Consultation Response from KC,
Ecology Unit

2025/93559 The Acres, 9, Greenfield Close, Upper Denby, Huddersfield, HD8 8UT

Use of land for siting of a camping pod

CLIENT MR & MRS A MARWOOD		DRAWING TITLE LOCATION PLAN			
PROJECT	THE ACRES, 9 GREENFIELD CLOSE, UPPER DENBY, HUDDERSFIELD, HD8 8UT	JOB NO WHPR 25-0095	DRG NO 01	REV B	SCALE @ A3 1:1250
				DATE 17 12 25

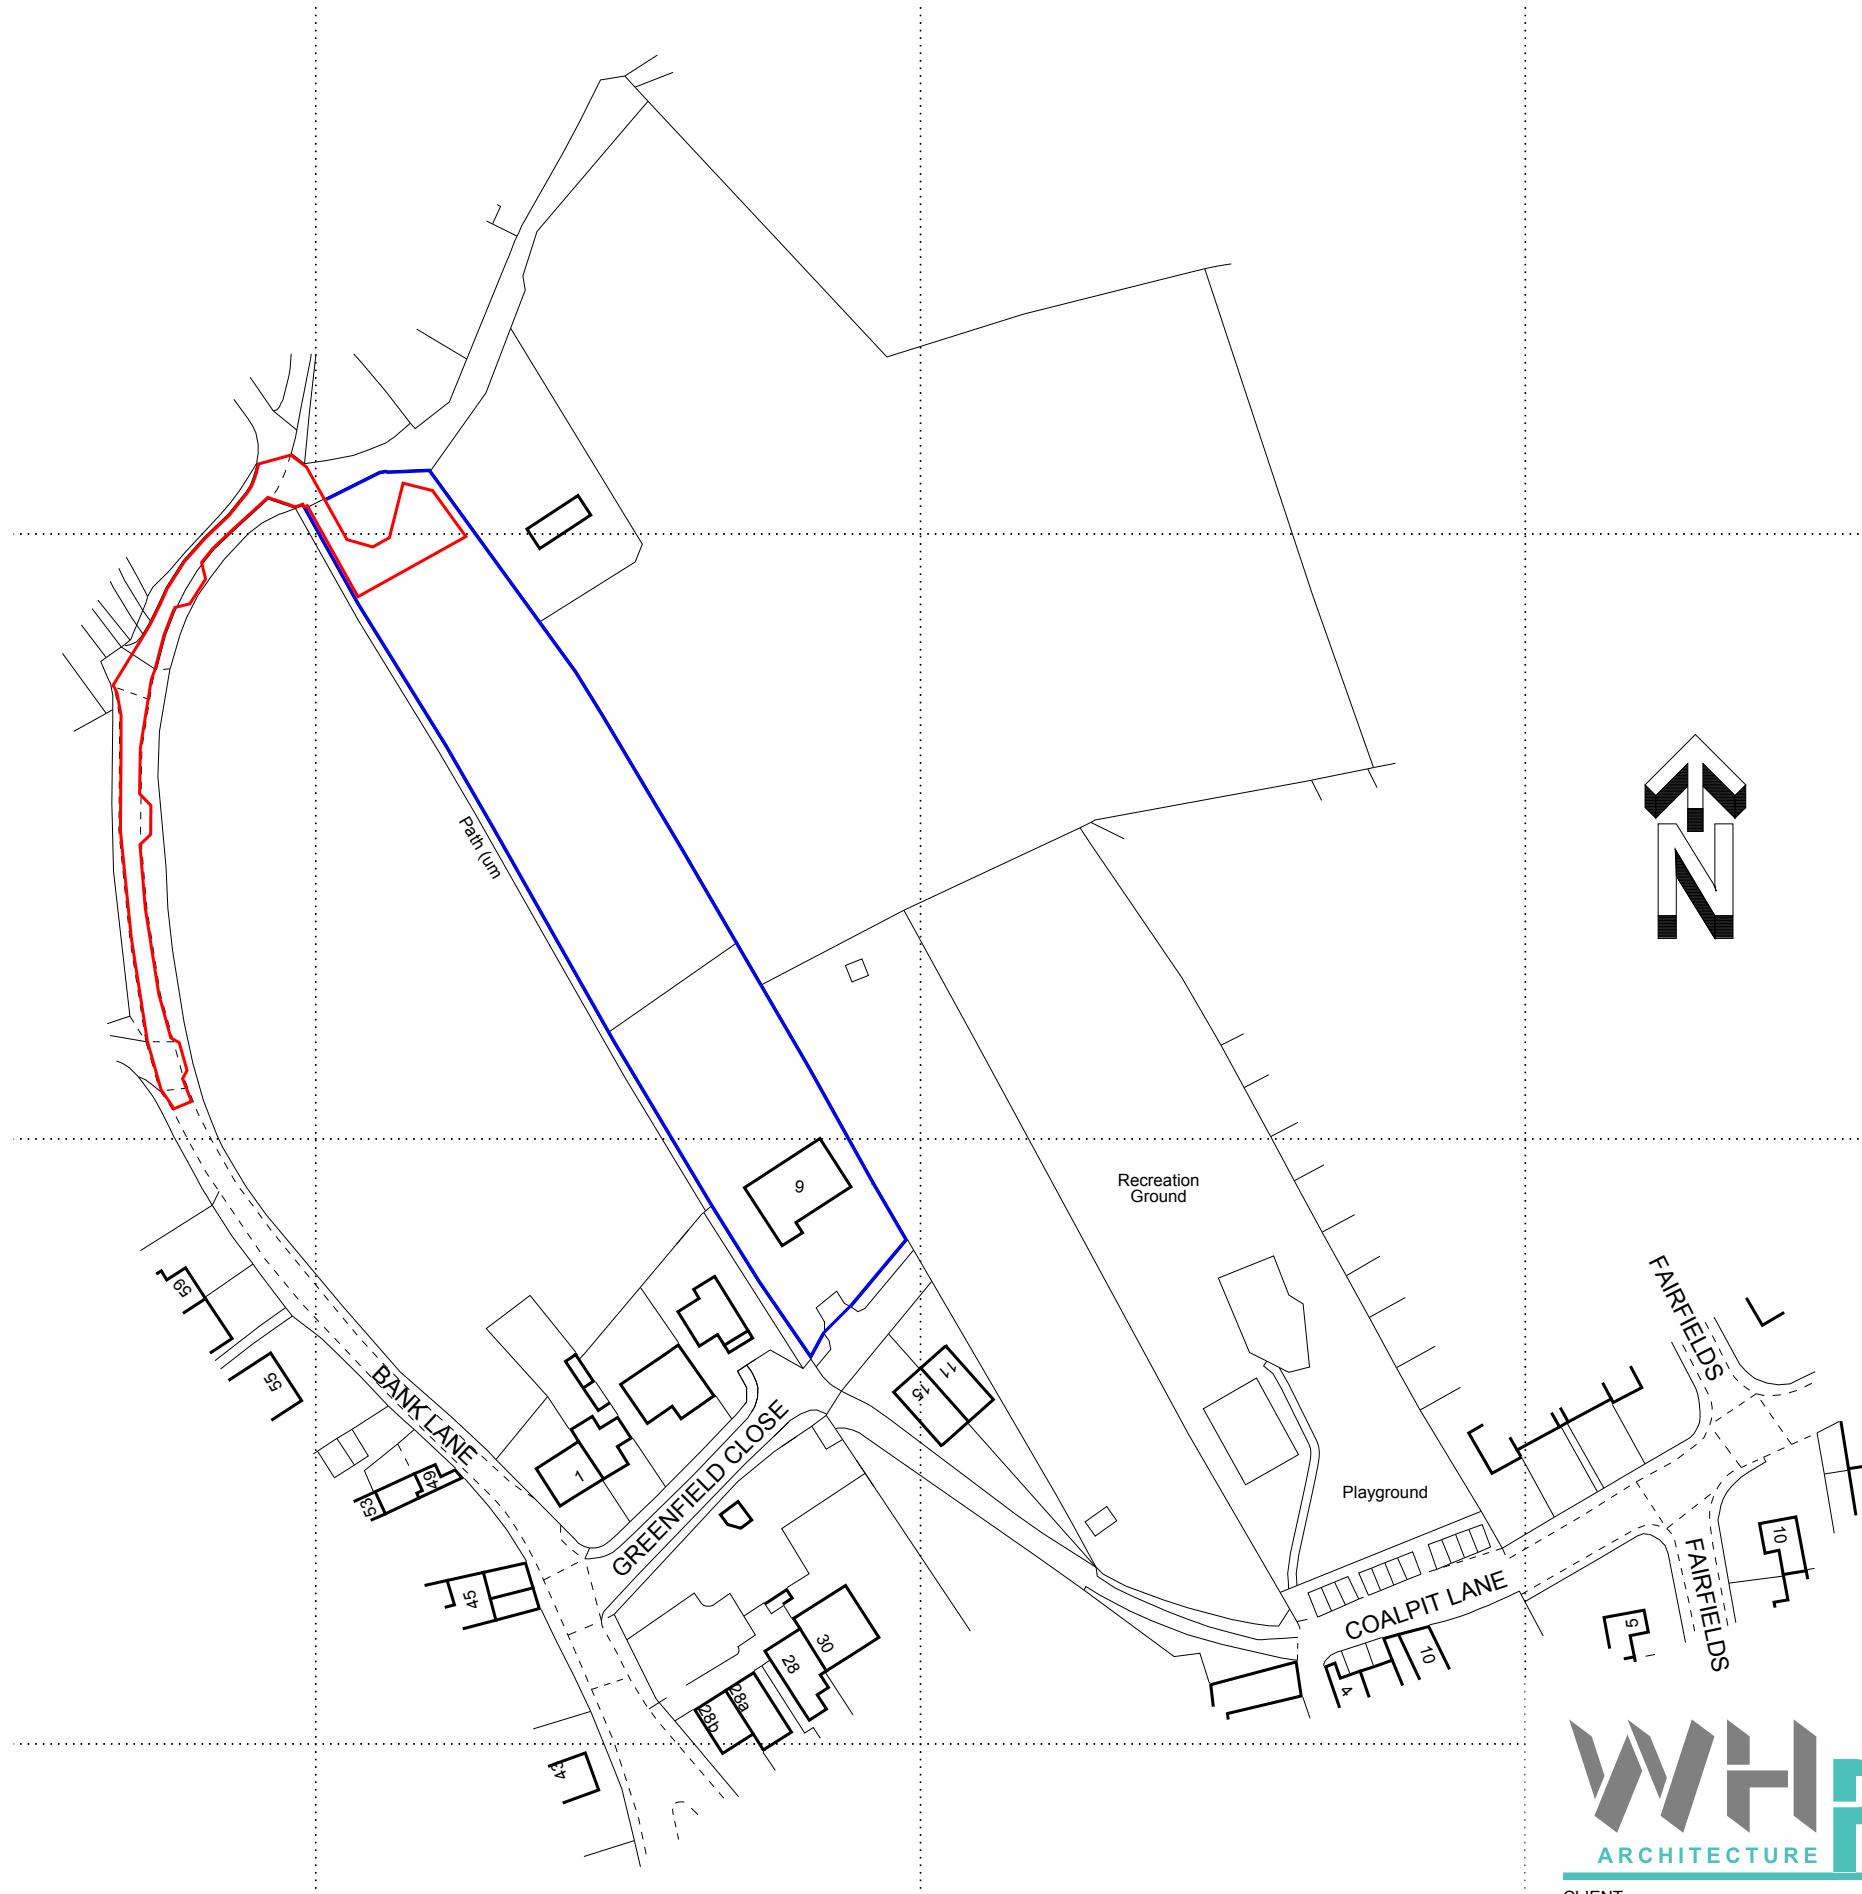
I have reviewed the information provided with this application. The Biodiversity Net Gain metric proposes off-site creation of individual rural trees, but I cannot tell where these will be. If this is referring to tree planting elsewhere on the applicants' land, then this will need to be secured via a section 106 agreement. Alternatively, the red line boundary of the development could be amended to include the area proposed for tree planting, and this will negate the need for a s106.

I would recommend that revised Biodiversity Net Gain information is provided to establish what is being proposed and enable the Authority to secure these appropriately. This information should be provided prior to determination, to enable appropriate assessment of the proposals.
